Please ask for: Mrs D Johnson
Email: daun.johnson@arun.gov.uk
Telephone: 01903 737762
Our Ref: FG/57/22/PL
Your Ref:
Date: 31st March 2022

Application for Planning Permission

Development: Demolition and erection of 1 No new dwelling. This application is in CIL Zone 4 and is CIL Liable as new dwelling.
Location: 12 Little Paddocks Ferring BN12 5NJ

**Drawing 2
Existing Floor Plans &
Elevations**

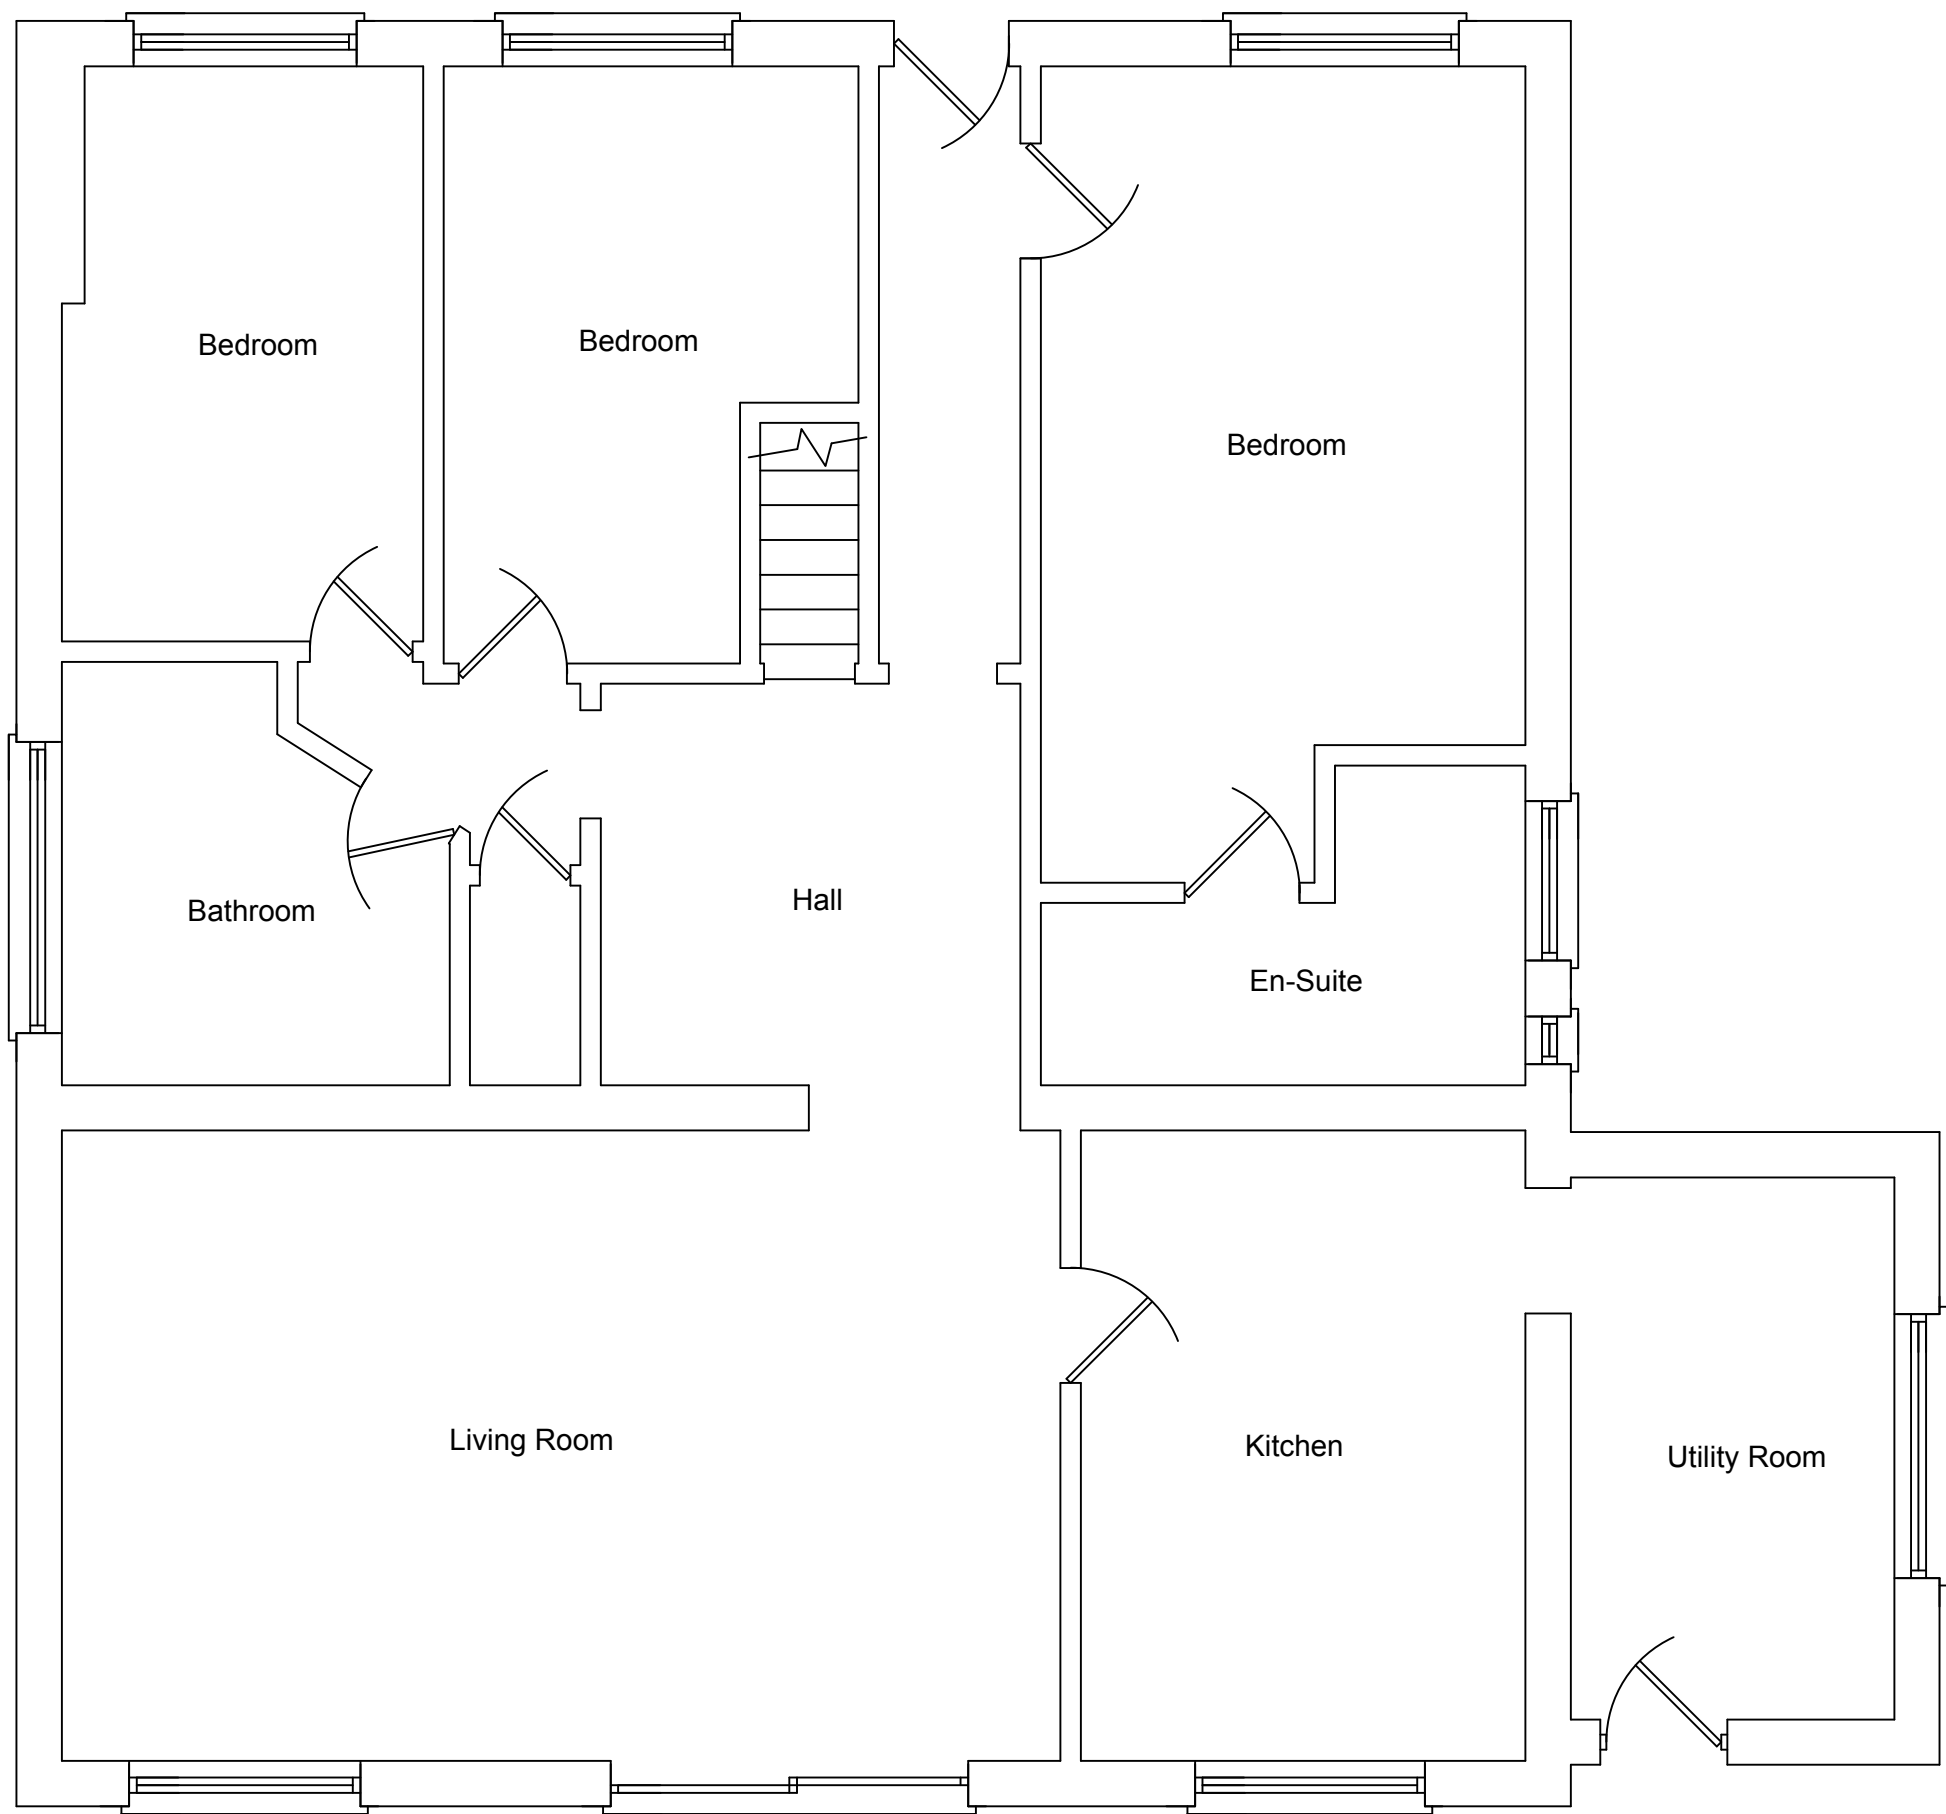
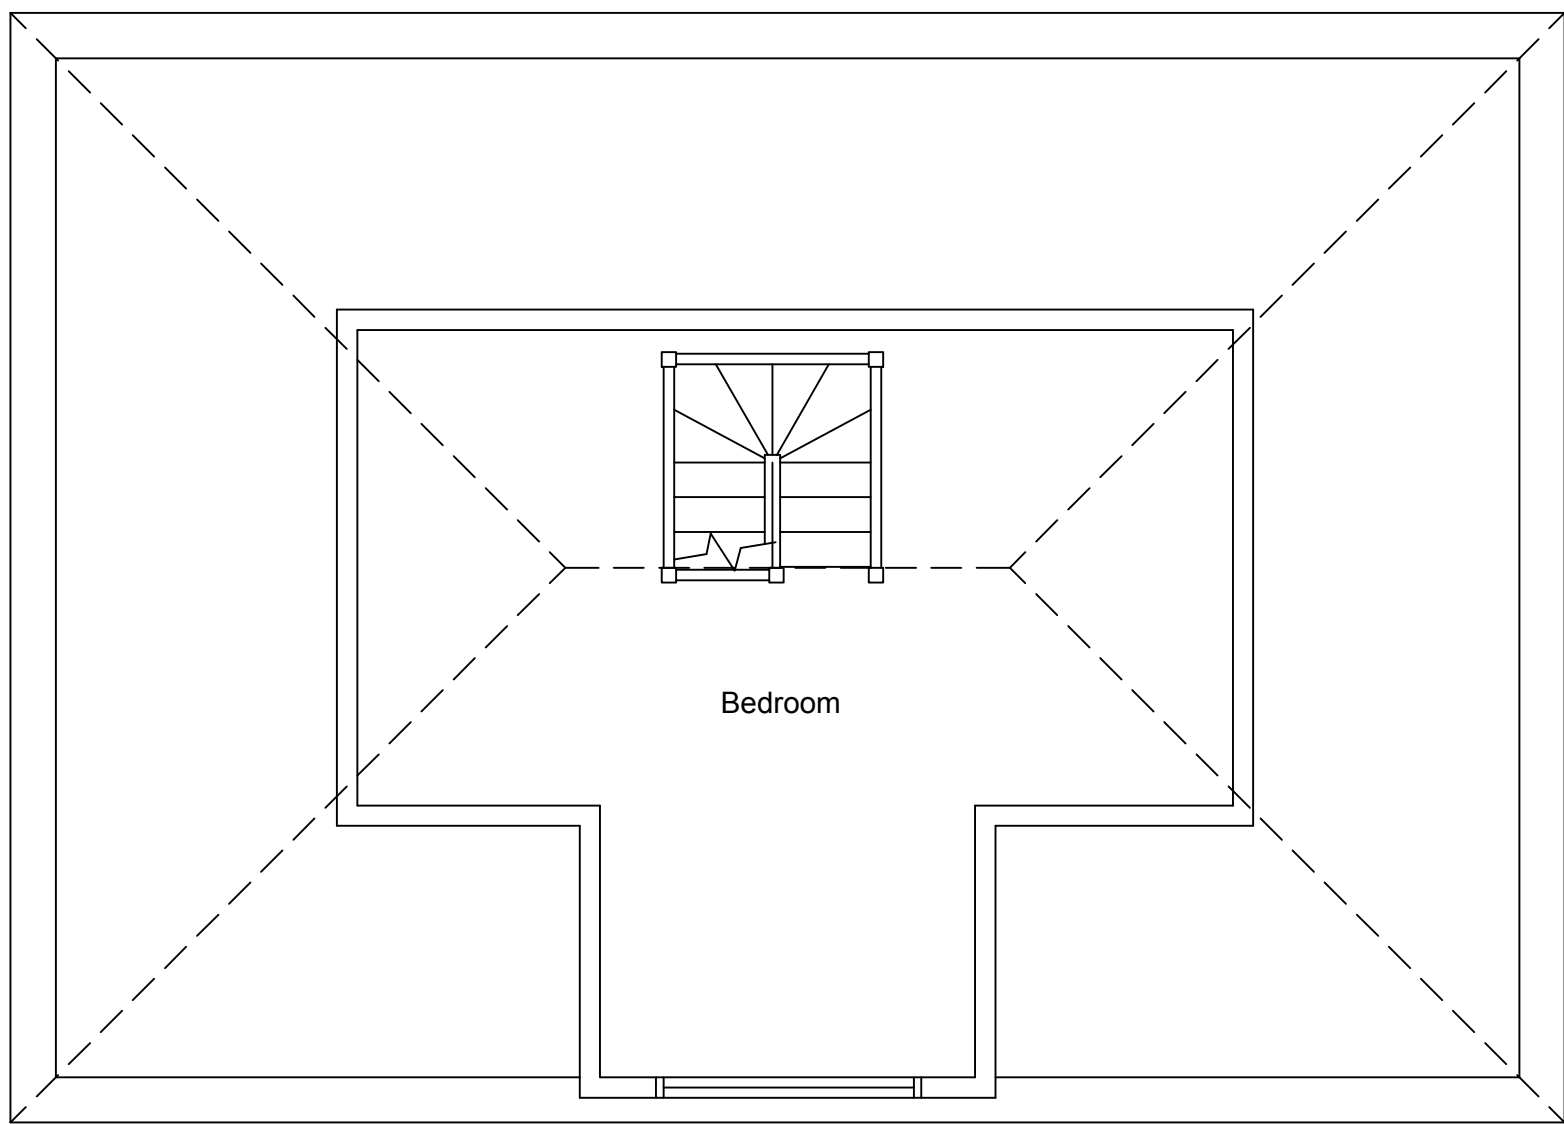
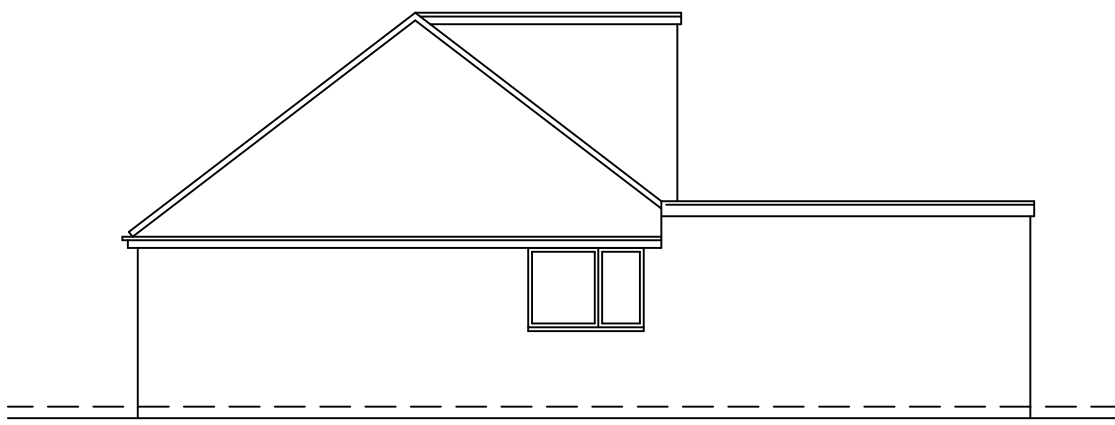
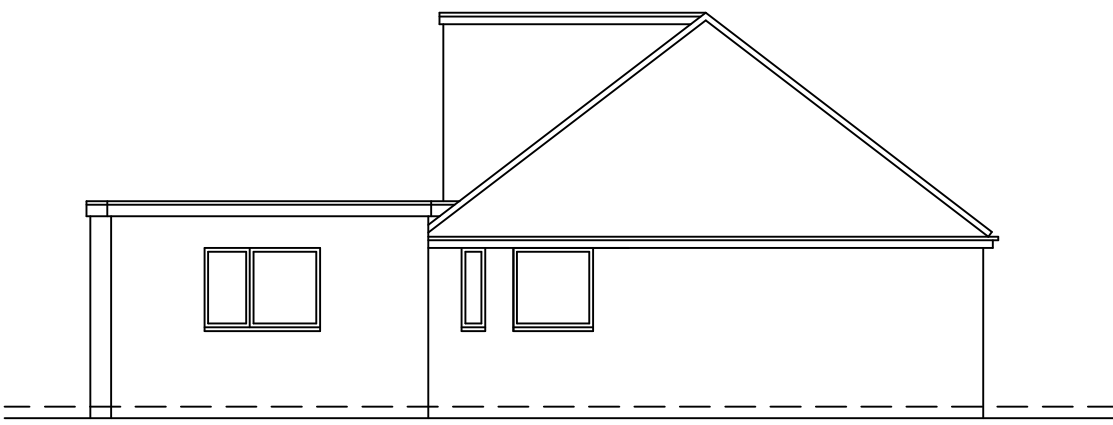
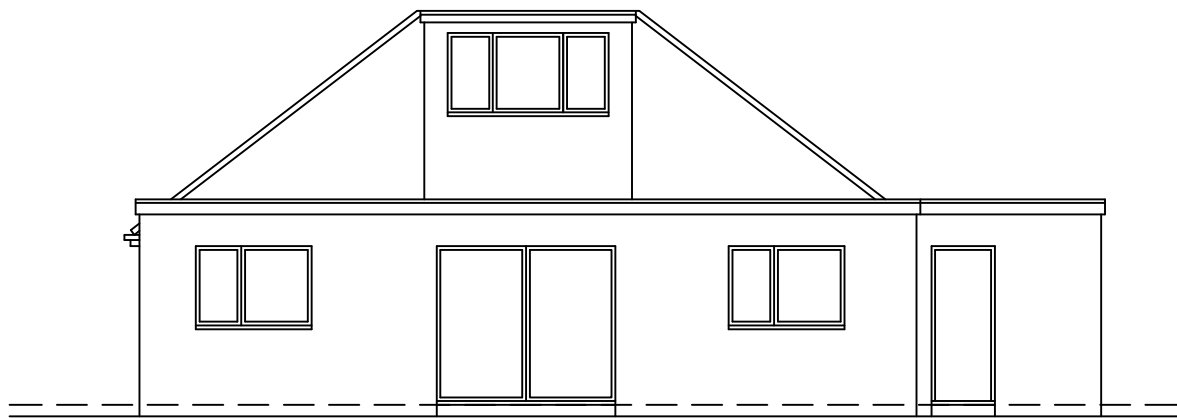
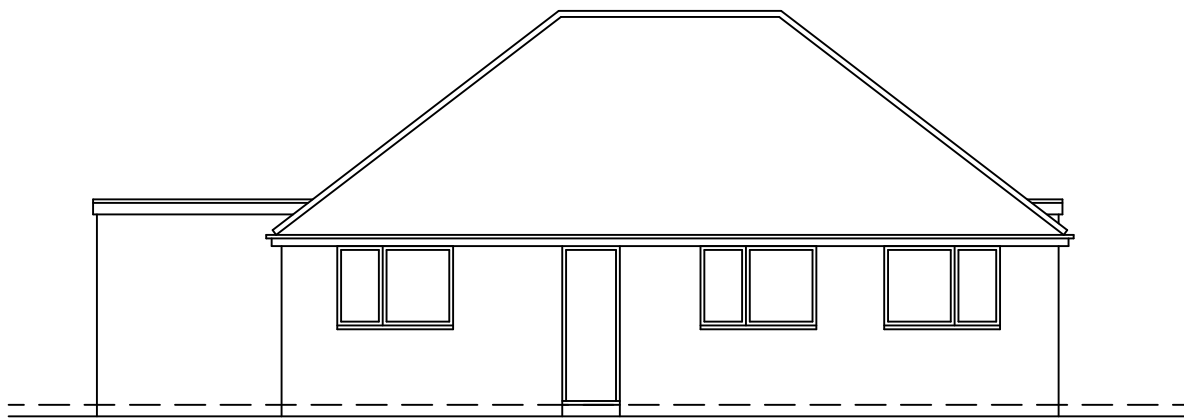
Please provide existing floor plans and elevations.

Drawing 6
Proposed Street Scene
& Site Plan

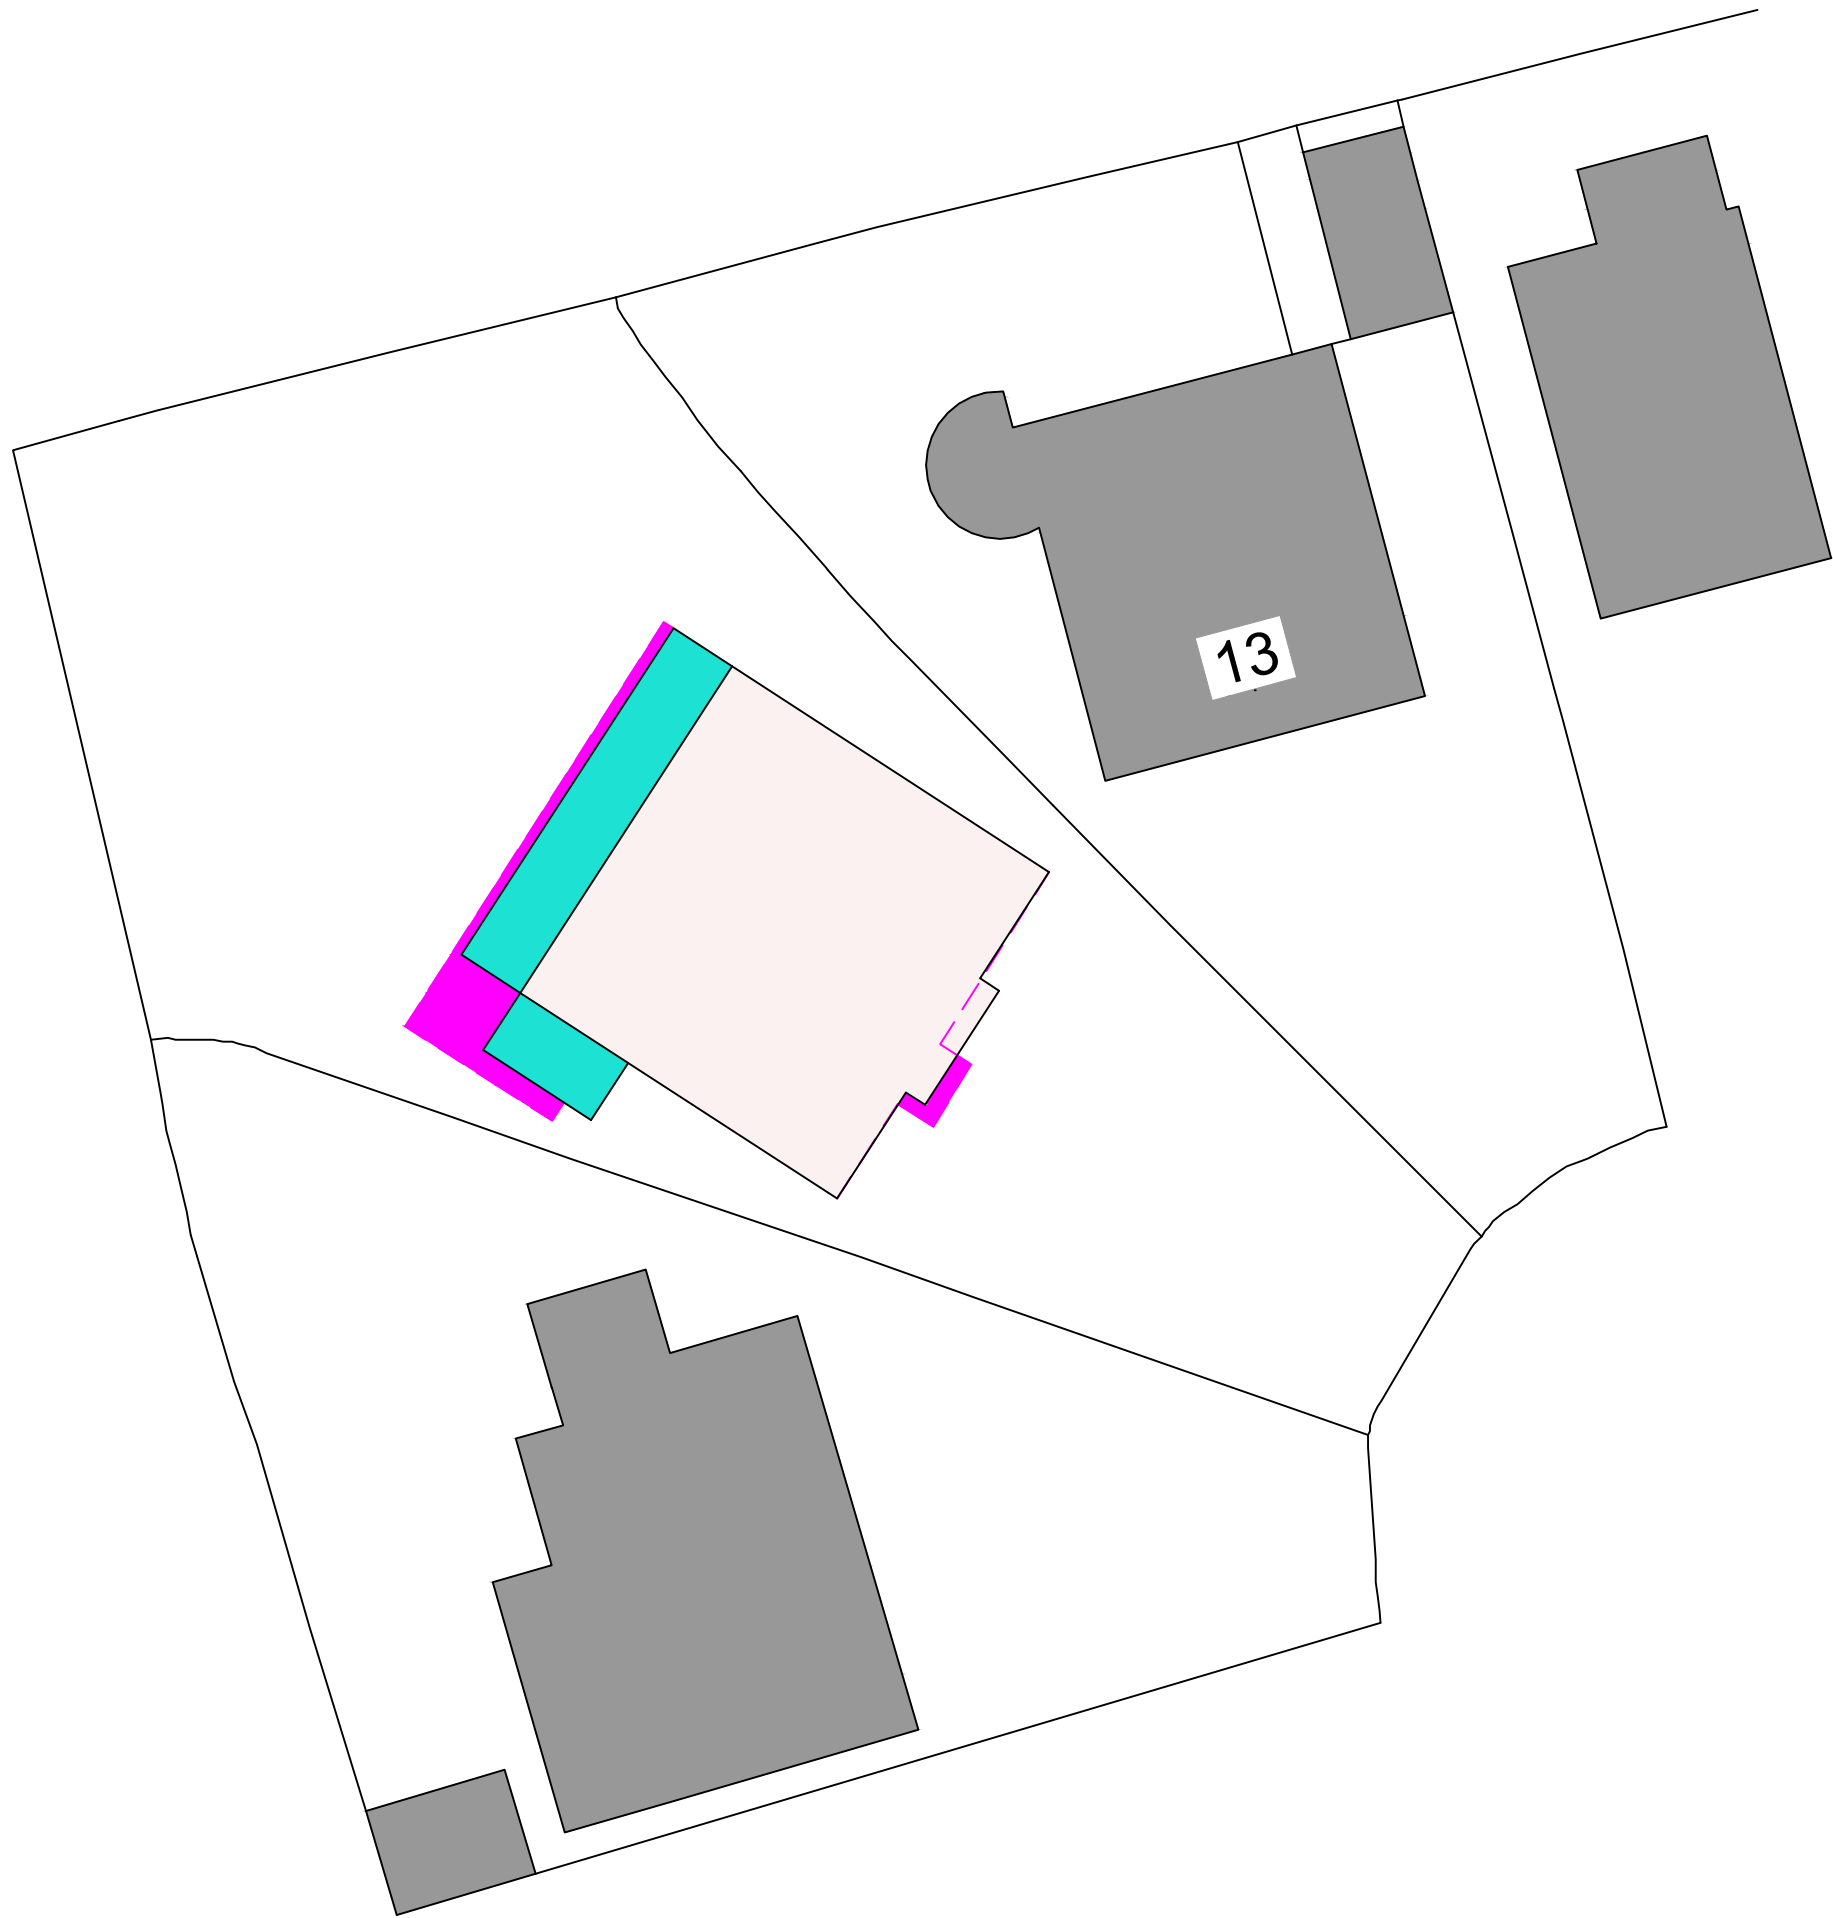
Street Scene

For all planning applications both residential and commercial which propose development set between existing buildings visible from the public realm it is a validation requirement to provide a street scene drawing or photomontage.

On either the block or site plan, please show the outline of the existing dwelling.
